Compliance with Major Project Application MP 10_0145 – Sydney Showground Main Arena Redevelopment

Thank you for your submission of the 6th March 2011 which provided material to demonstrate compliance with the provisions of Condition B1 – Detailed Design Information.

**Figure 11: Fencing Detail and layout (shown in blue)**

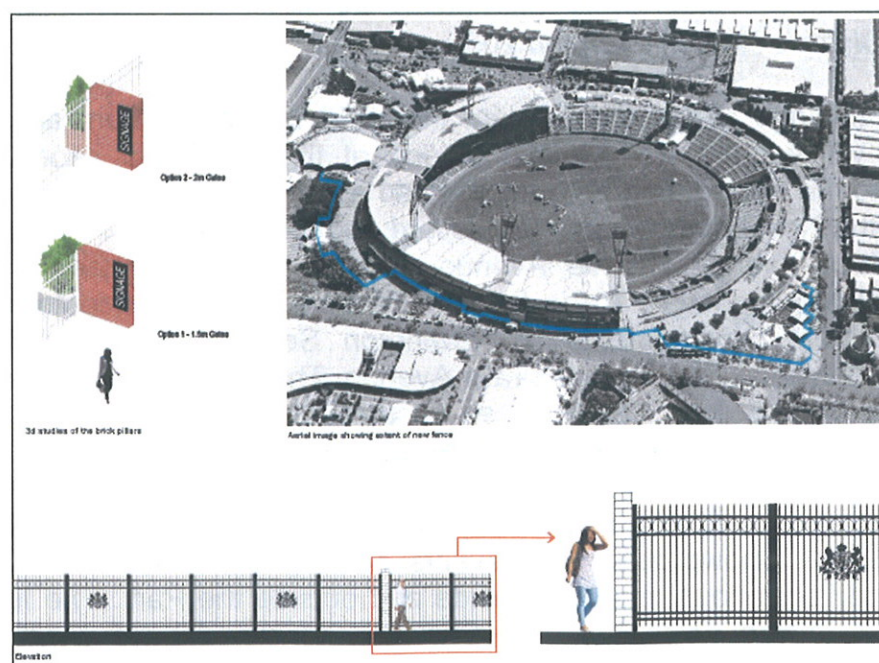
It is noted that the proposed perimeter fence introduces a new type of fencing to the precinct. Traditionally galvanised steel fencing rather than powder coated fencing has been used throughout Sydney Olympic Park as well as the RAS precinct (see attached photo and standard fence detail from the Urban Elements Design Manual, SF16). In addition to this, the preferred type of palisade fencing has a 19mm diameter MS rod design which is lighter and more transparent than the 25 mm square bars provided in your sample.

In addition, more attention could be given to the detail and layout of the perimeter fencing at the Hawkesbury Street corner so that it is more coordinated with the existing trachyte walls, a feature of this corner. Likewise it is recommended that the footing around the existing Fig Trees be hand excavated and that an Arborist be consulted in this matter, to minimise damage to tree roots.
